**WELWYN HATFIELD BOROUGH COUNCIL
EXECUTIVE DIRECTOR - PLANNING, PUBLIC PROTECTION AND GOVERNANCE**

DELEGATED APPLICATION

Application No: 6/2017/1079/FULL
Location: Land adjacent to 37-48 Lambs Close, Cuffley, Potters Bar, EN6
 4HD
Proposal: The erection of 3 x 2 bedroom flats
Officer: Mr D Elmore

Recommendation: Refused

1 Proposed Second Floor Plan
1:50

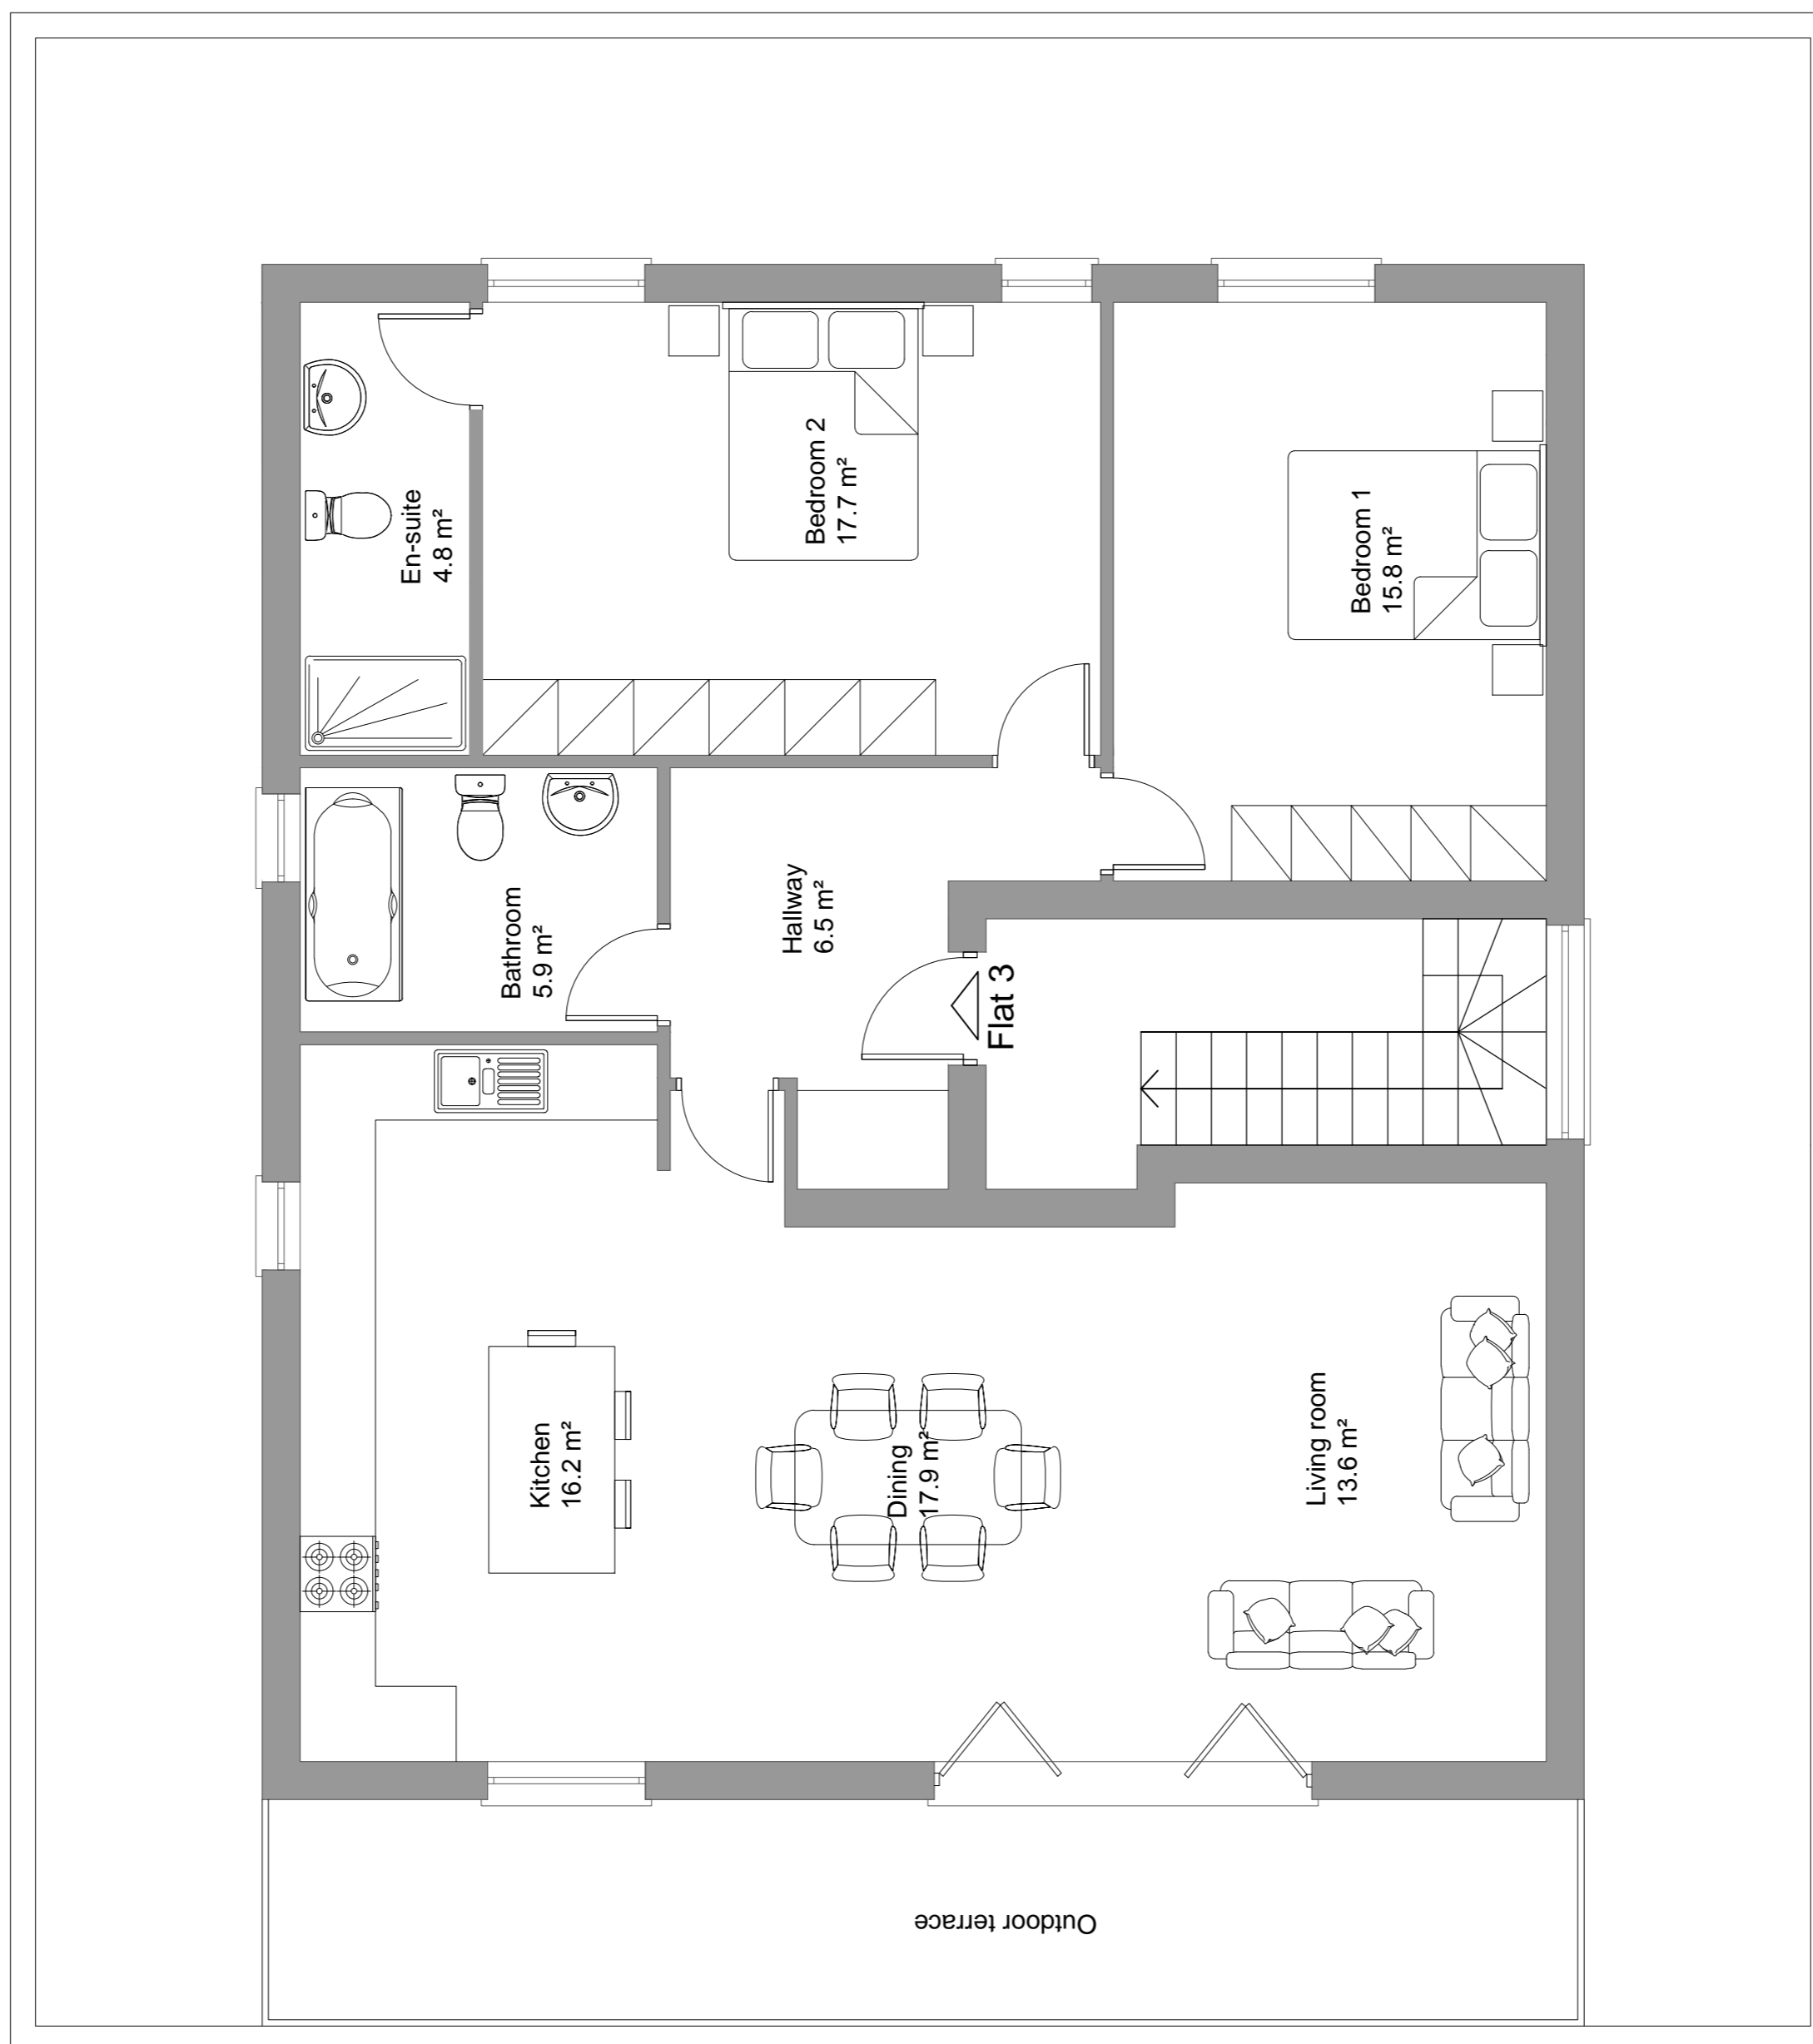
<p>Conclusion</p>	
<p>The second floor south elevation windows, serving a bathroom and kitchen for Flat 3, by virtue of their height, design and positioning, would present both direct and perceived overlooking toward the private rear garden of number 3 Theobalds Close, detrimental to the levels of privacy currently enjoyed by the occupiers of this property. Accordingly, the proposed development would be contrary to Policy D1 of the Welwyn Hatfield District Plan 2005, Supplementary Design Guidance 2005 (Statement of Council Policy 2005) and relevant provisions of the National Planning Policy Framework 2012.</p> <p>The provision of 3 off-street car parking spaces would be inadequate for the proposed three, two bedroom flats, and given the clear demonstrable lack of existing car parking provision for the Lambs Close Development, it is not considered that the shortfall of off-street parking serving the proposed development would be acceptability offset via off-street and on-street parking elsewhere within the immediate vicinity. As such, the proposal development is contrary to Policy M14 of the Welwyn Hatfield District Plan 2005, Supplementary Planning Guidance 2004 (Statement of Council Policy), Interim Policy for Car Parking Standards and Garage Sized 2014 (Statement of Council Policy) and National Planning Policy Framework 2012.</p> <p>The applicant has failed to provide a planning obligation under Section 106 of the Town and Country Planning Act 1990 (as amended). The Local Planning Authority considers that it would be inappropriate to secure the number of parking spaces and cycle storage units for the use proposed by any method other than a legal agreement and the proposal is therefore contrary to the Policy IM2 of the Welwyn Hatfield District Plan 2005 and National Planning Policy Framework 2012.</p>

1. The second floor south elevation windows, serving a bathroom and kitchen for Flat 3, by virtue of their height, design and positioning, would present both direct and perceived overlooking toward the private rear garden of number 3 Theobalds Close, detrimental to the levels of privacy currently enjoyed by the occupiers of this property. Accordingly, the proposed development would be contrary to Policy D1

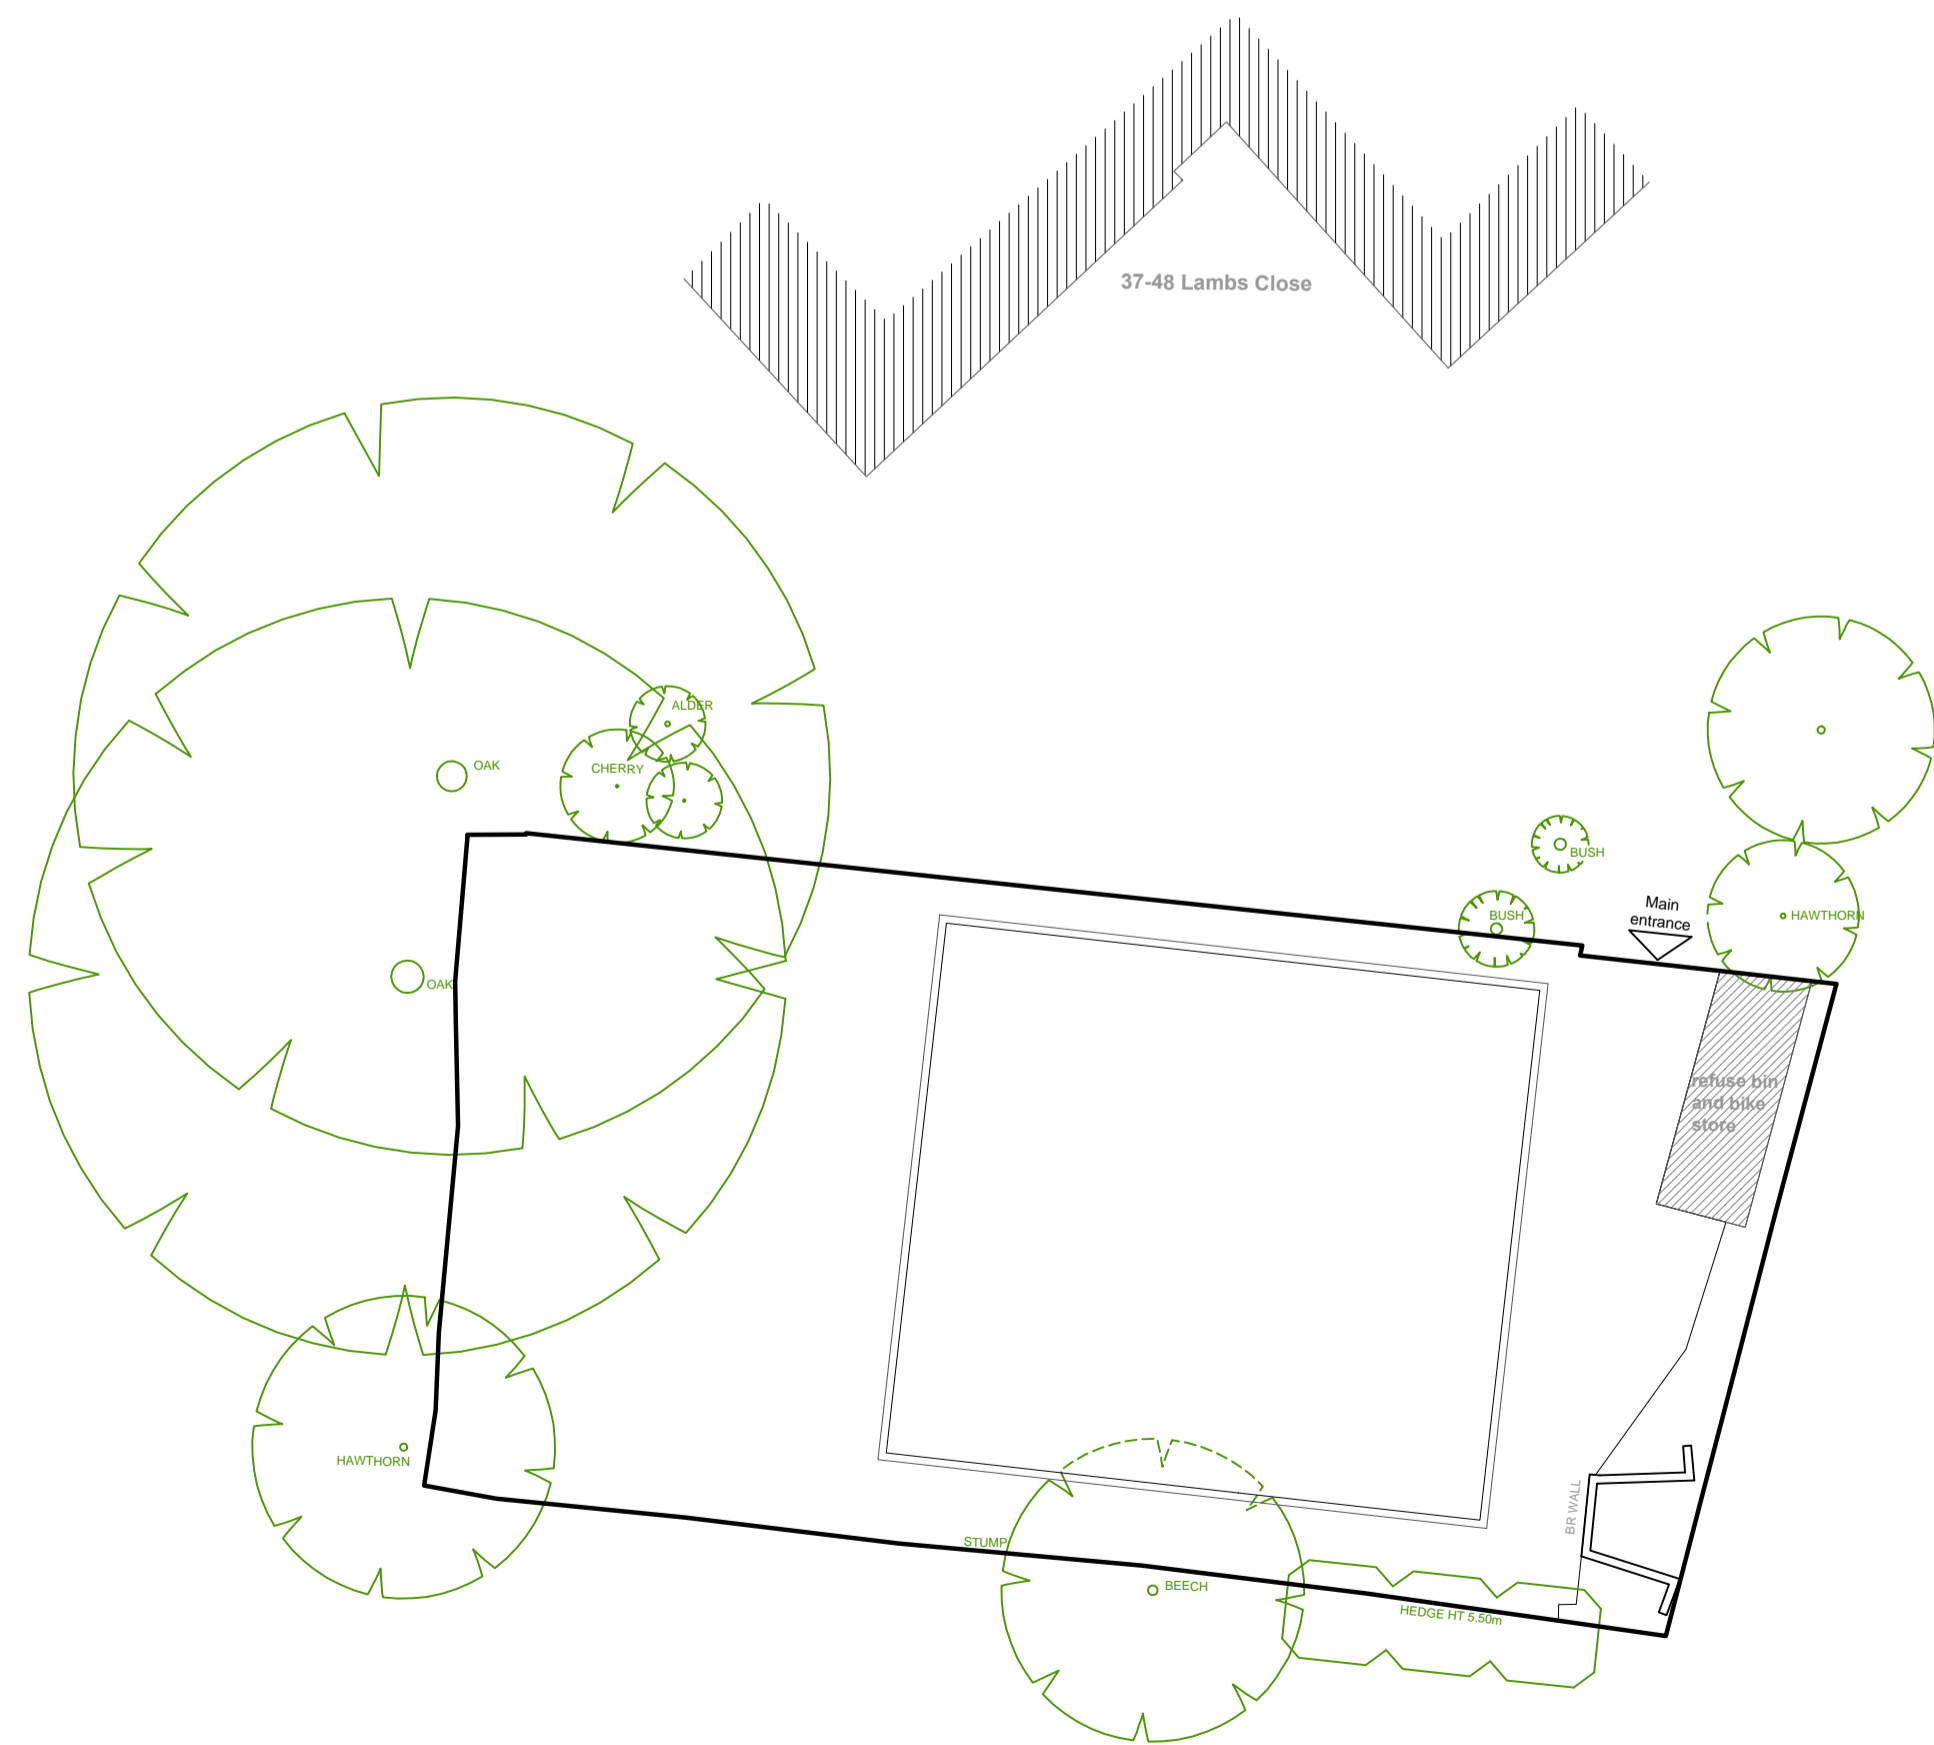
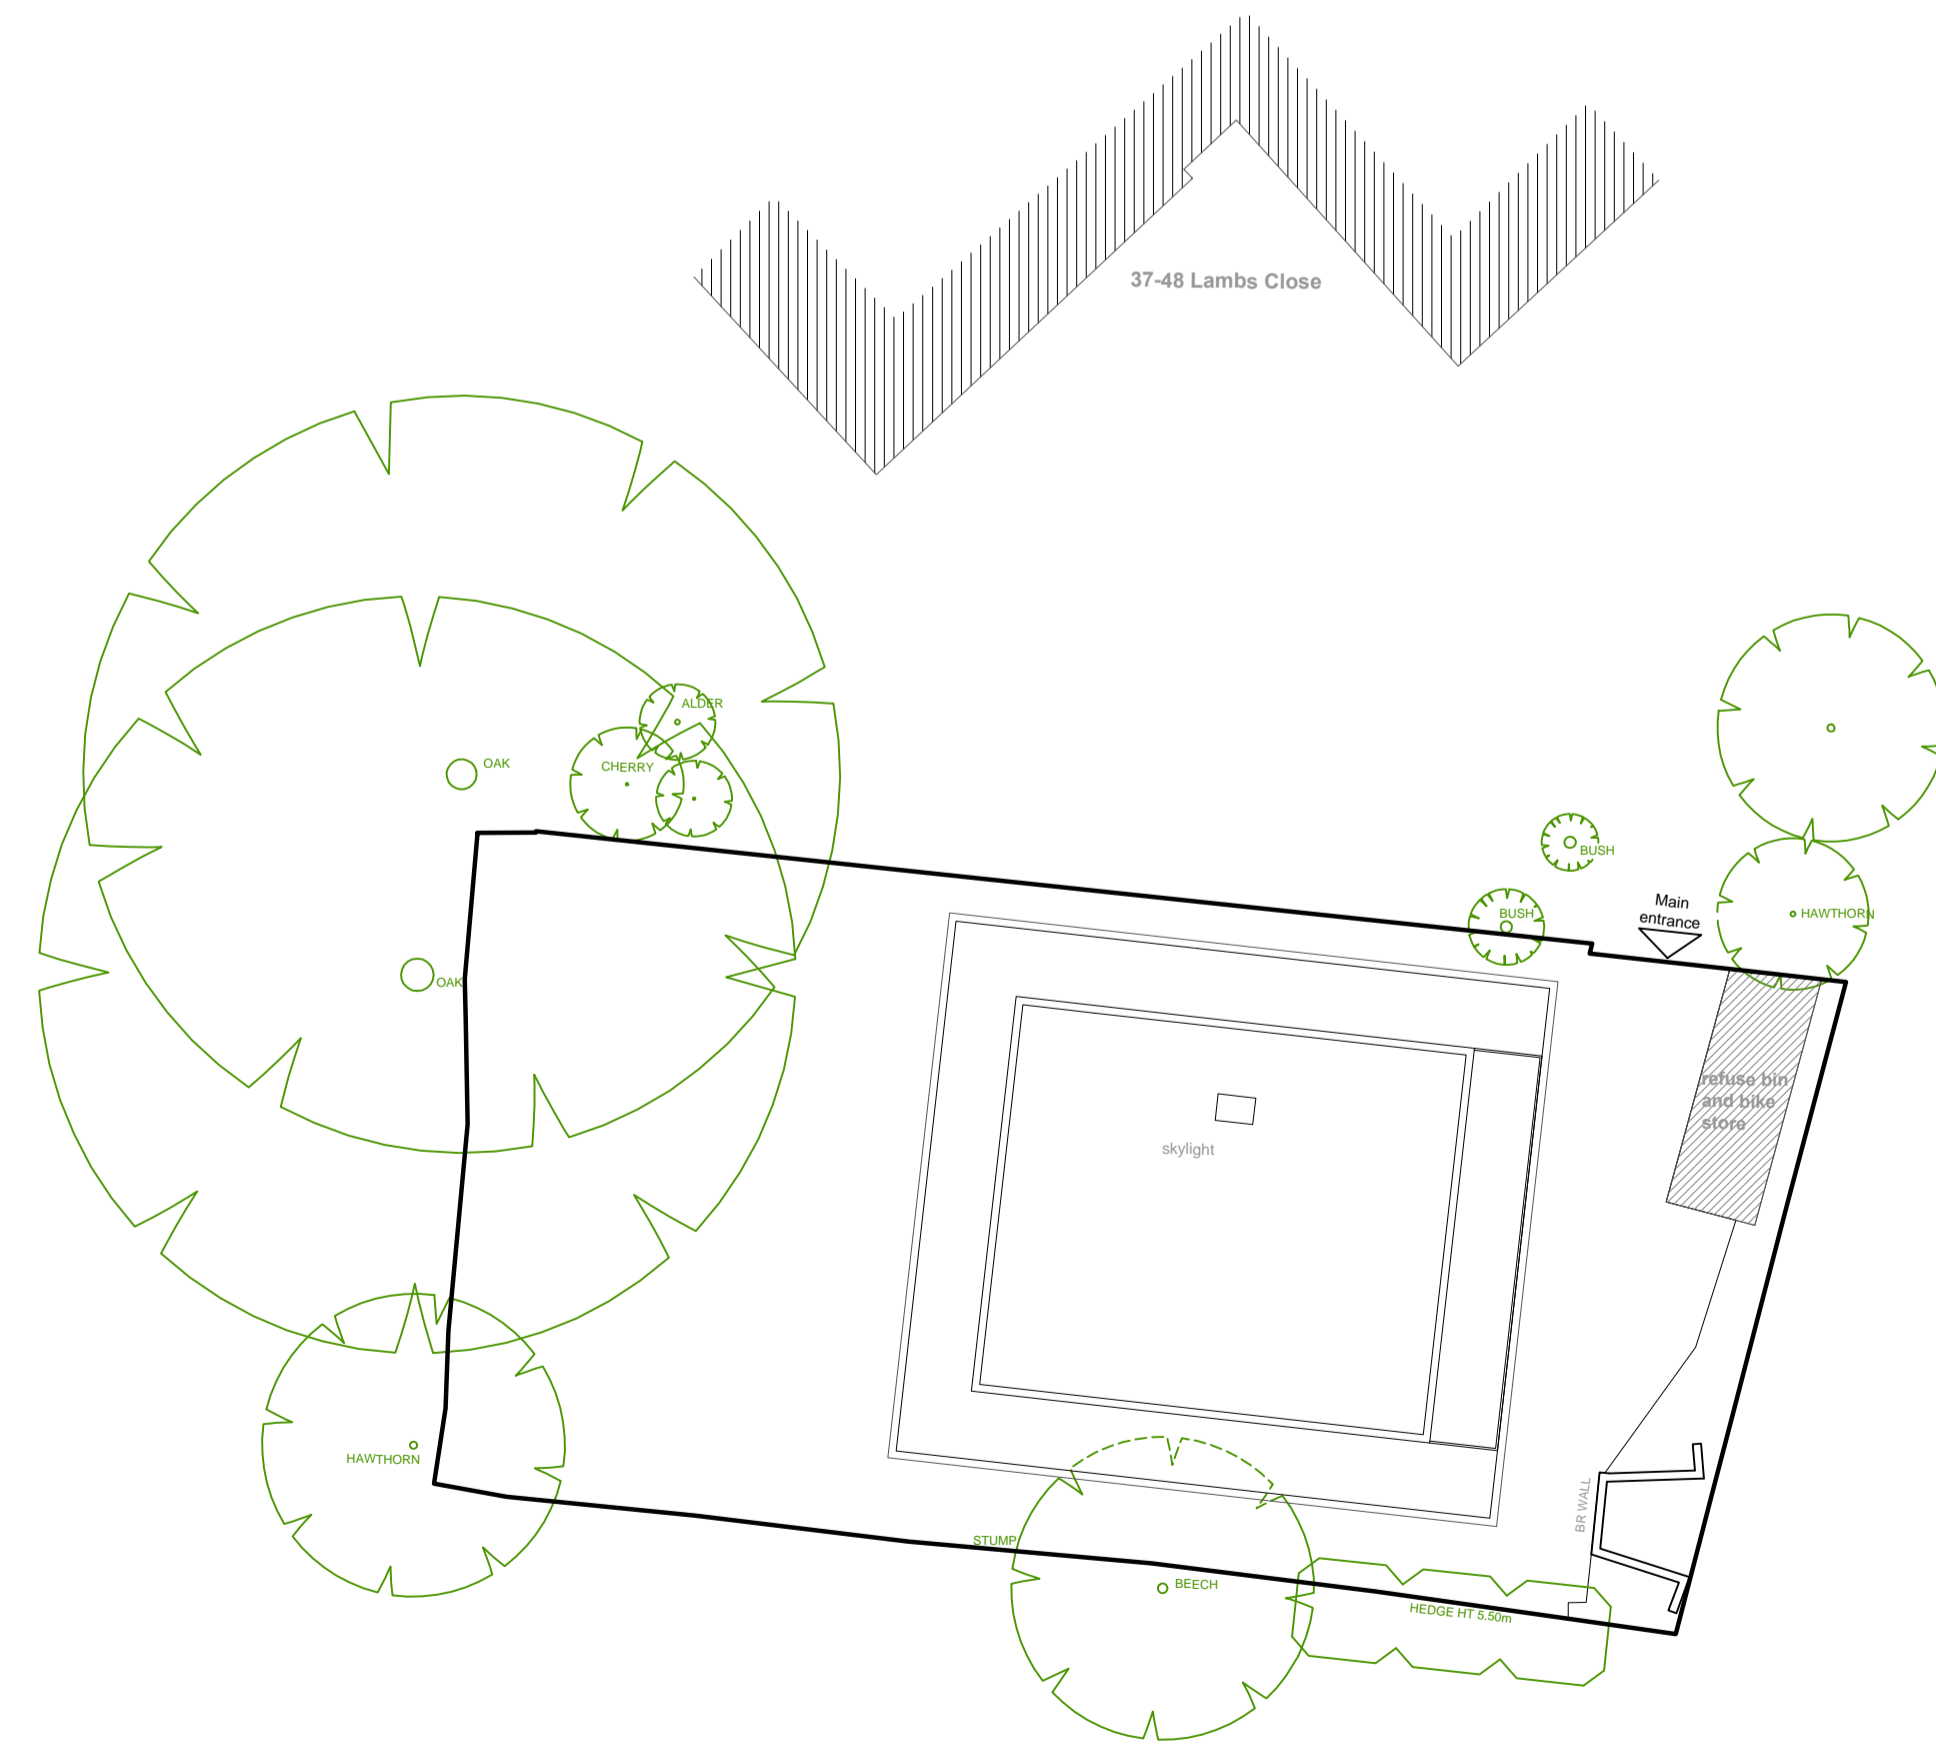
2. The provision of three off-street car parking spaces would be inadequate for the proposed three, two bedroom flats, and given the clear demonstrable lack of existing car parking provision for the Lambs Close Development, it is not considered that the shortfall of off-street parking serving the proposed development would be acceptability offset via off-street and on-street parking elsewhere within the immediate vicinity. As such, the proposal development is contrary to Policy M14 of the Welwyn Hatfield District Plan 2005, Supplementary Planning Guidance 2004 (Statement of Council Policy), Interim Policy for Car Parking Standards and Garage Sized 2014 (Statement of Council Policy) and National Planning Policy Framework 2012.
